30/11/20

15 Hazel Avenue
Withernsea
East Riding of Yorkshire
HU19 2PQ.

As regarding our telephone conversation on 26-11-'20 re new build on carpark, here are my concerns in writing as requested.

**SECTION THRO' A-A**  
PROPOSED - SCALE 1:50

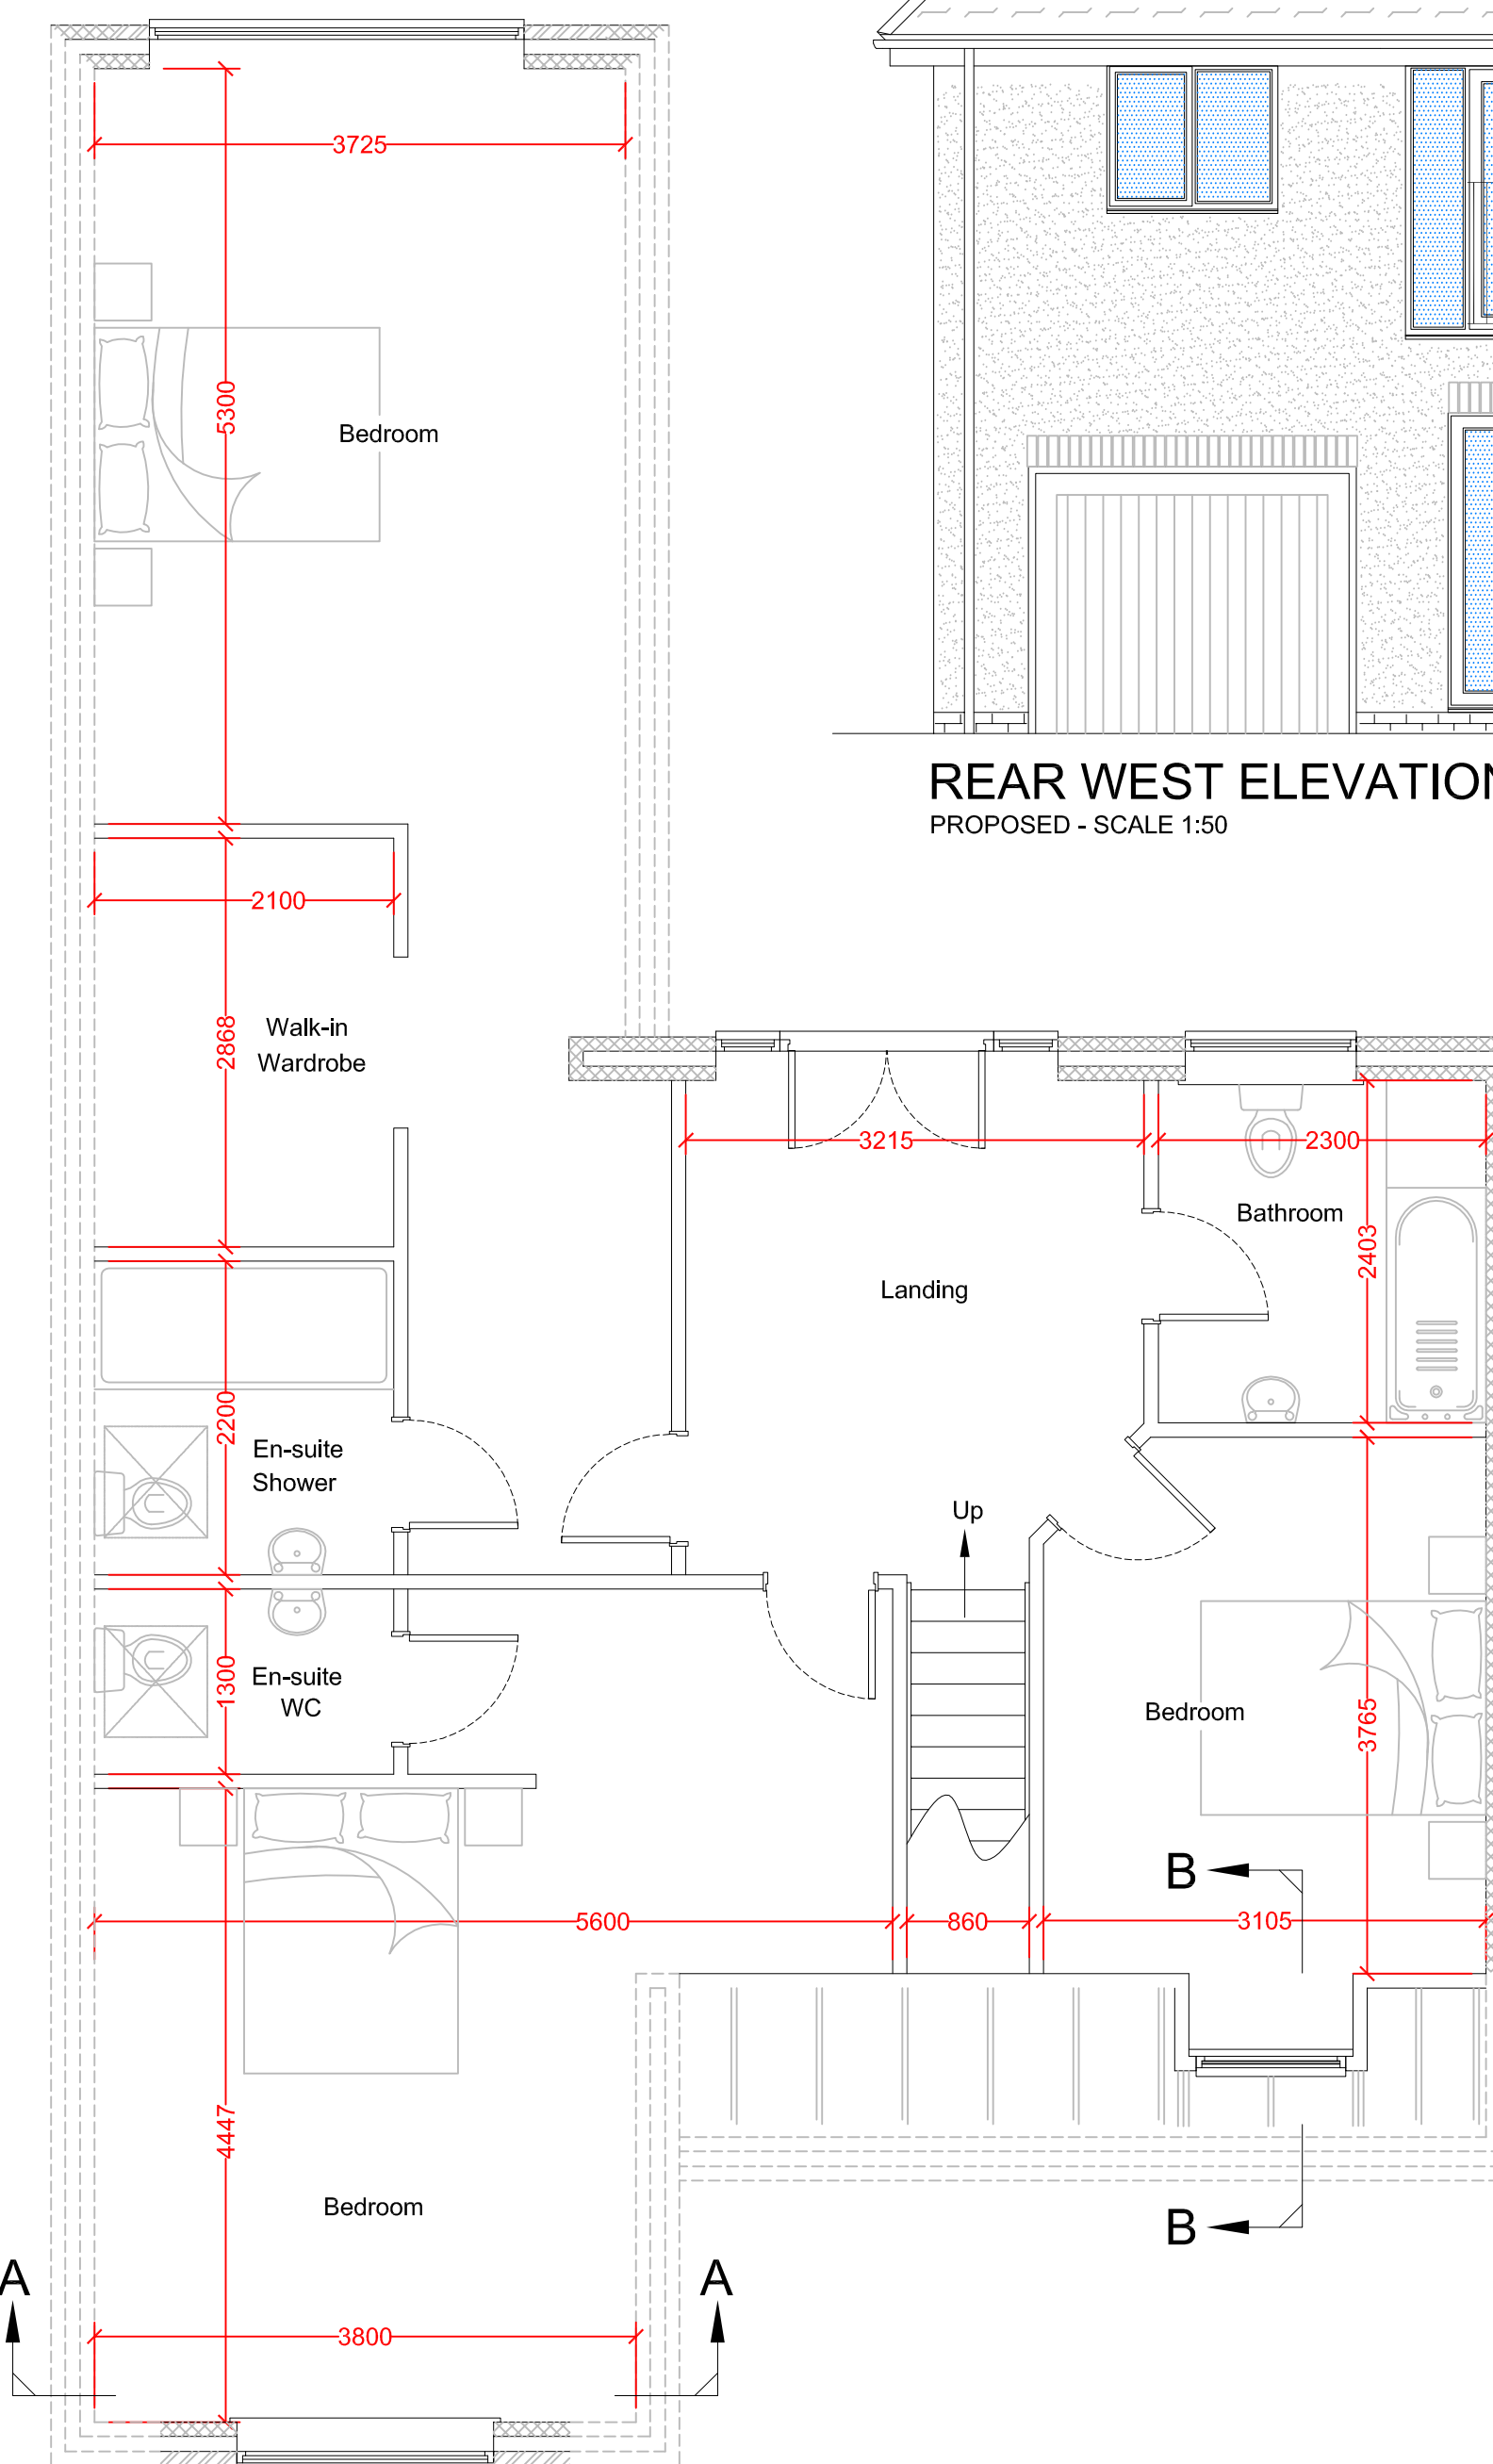
- ① I was assured by yourself in Nov 2019 that any proposed new build would be a bungalow no higher than No 13 to be in keeping with other properties. Now I see from the submitted plans that a two storey dwelling is being proposed.
- ② A four bedroomed house is being proposed. Two story build which is a house not a bungalow. I am very disappointed that plans are being submitted for such a build.
- ③ After our conversation I am

AMENDMENTS 2B (20.10.20) Amended for client 2C (28.10.20) Amended for client 2D (4.11.20) Amended for client 2E (21.11.20) Amended for DC	DRAWING No. ELDON 08 2020 2E SCALE 1:200 & 1:1250 @ A2
---	---

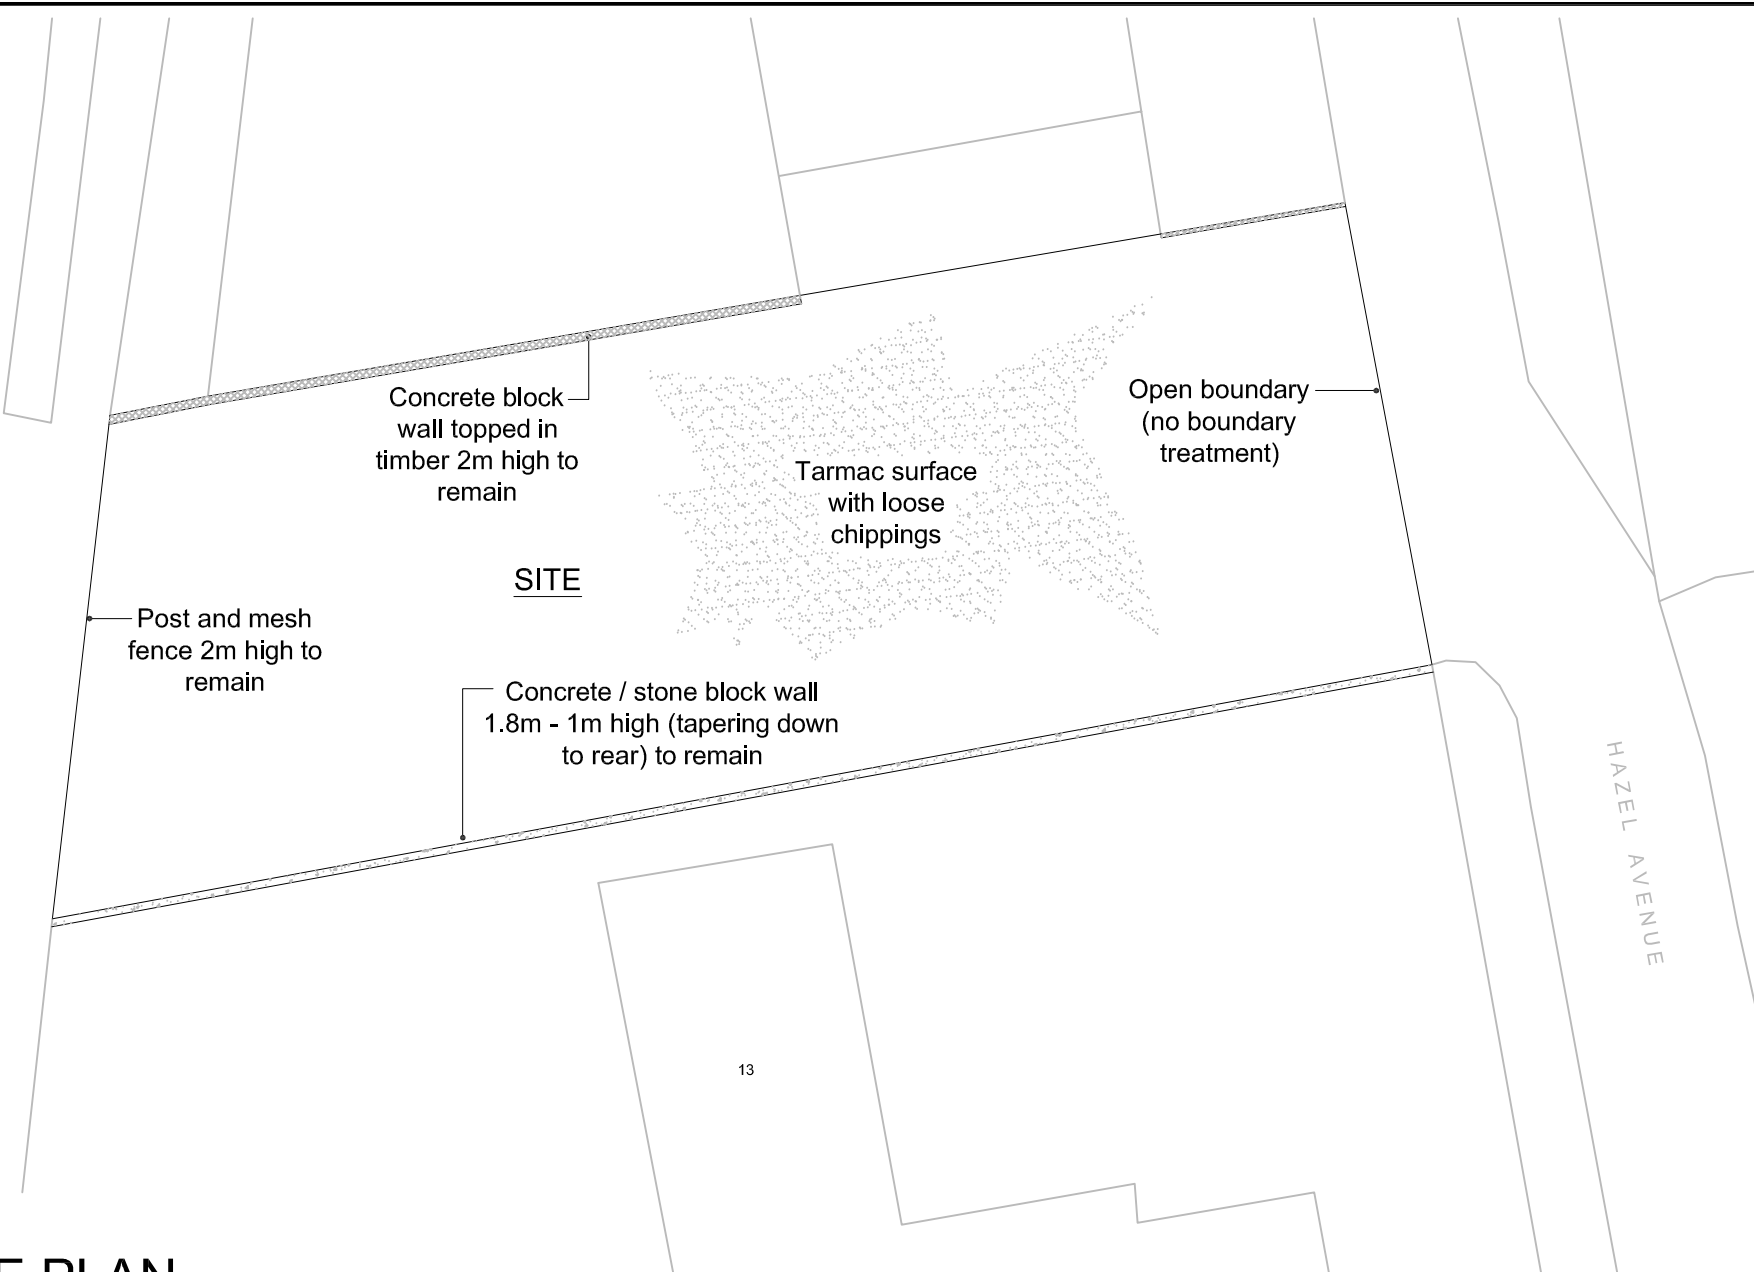
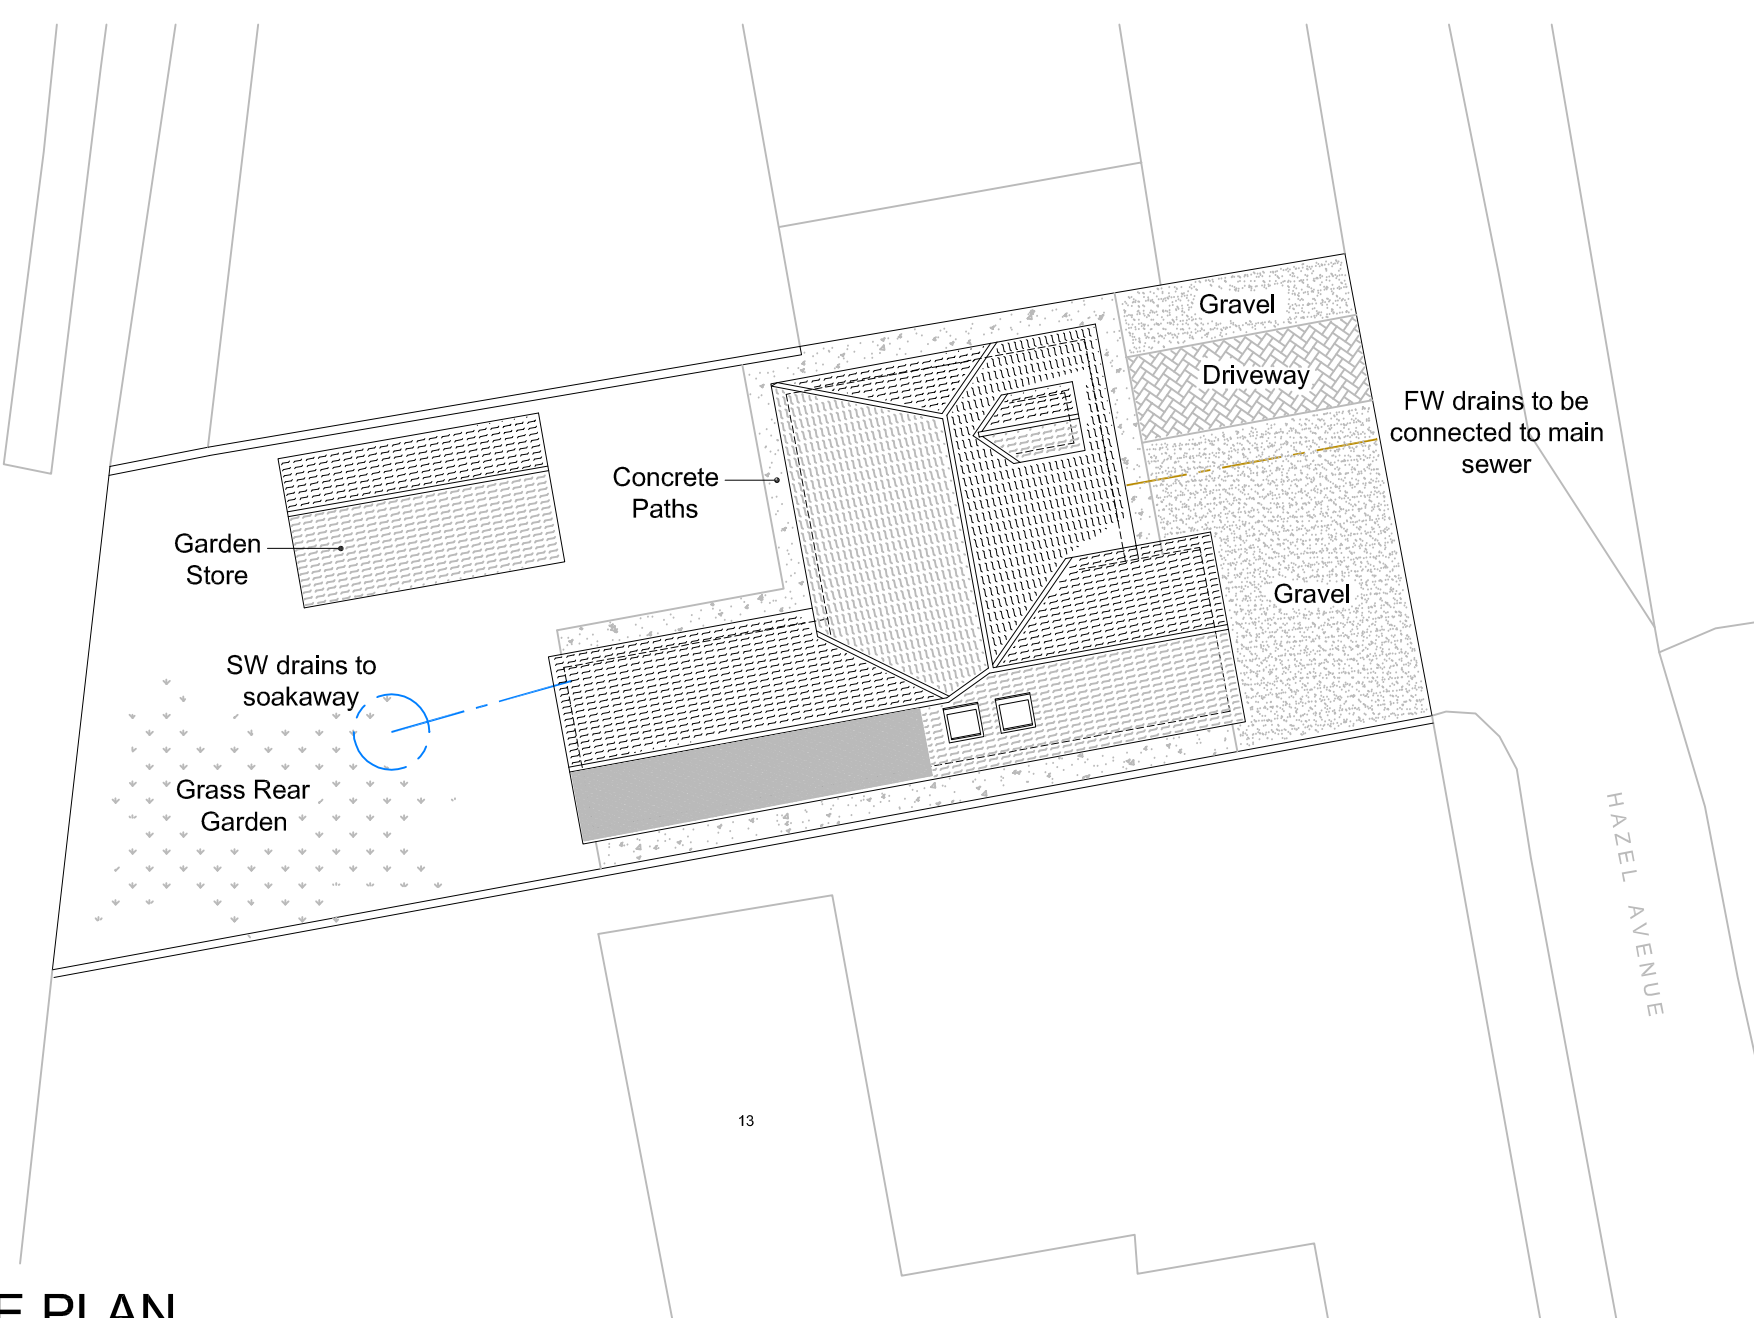
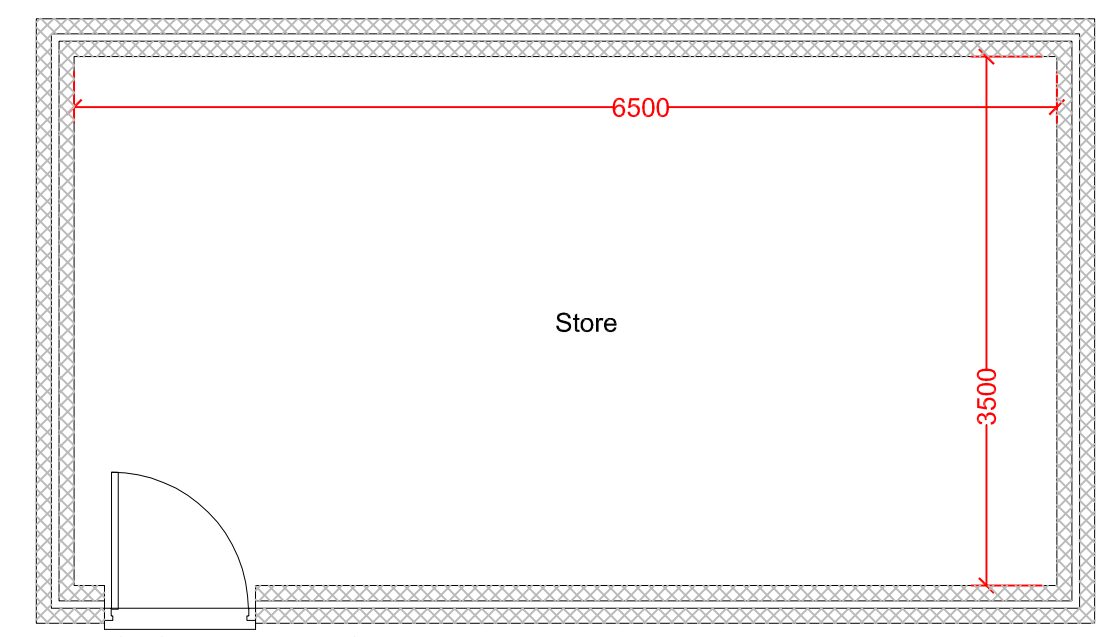
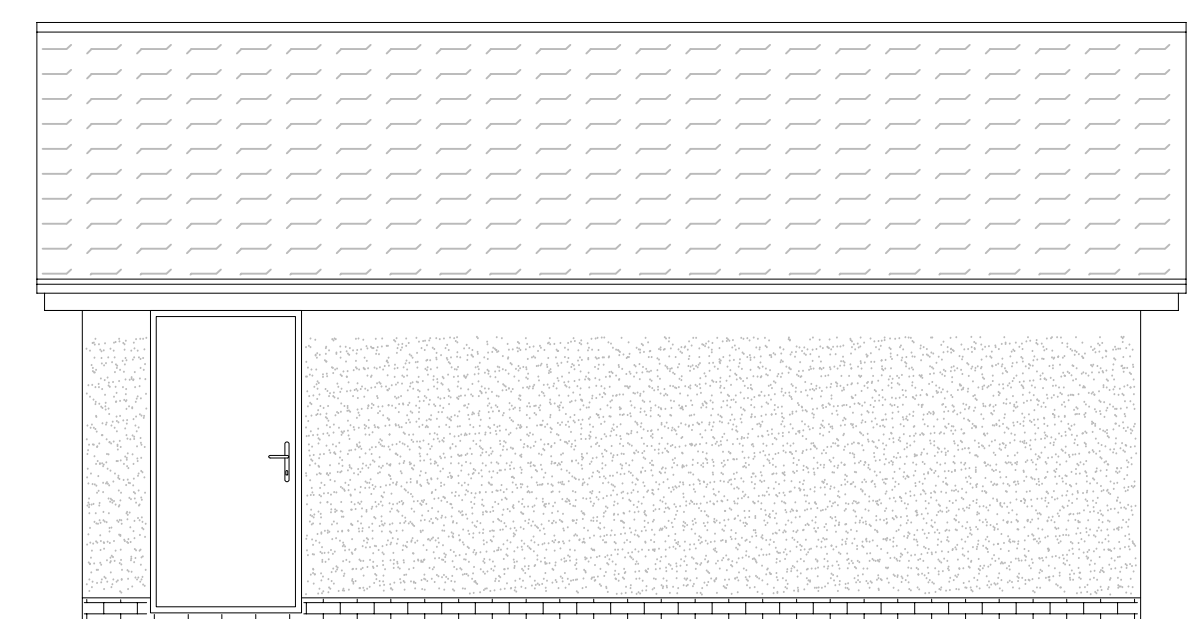
6) I see on the plans for a large garden store, "not a shed". Will this block my right to light?

3) My husband has had a more detailed look at the plans we have and is very concerned that the "garden store" will block out a lot of our sunshine, which could impact on my growing season.
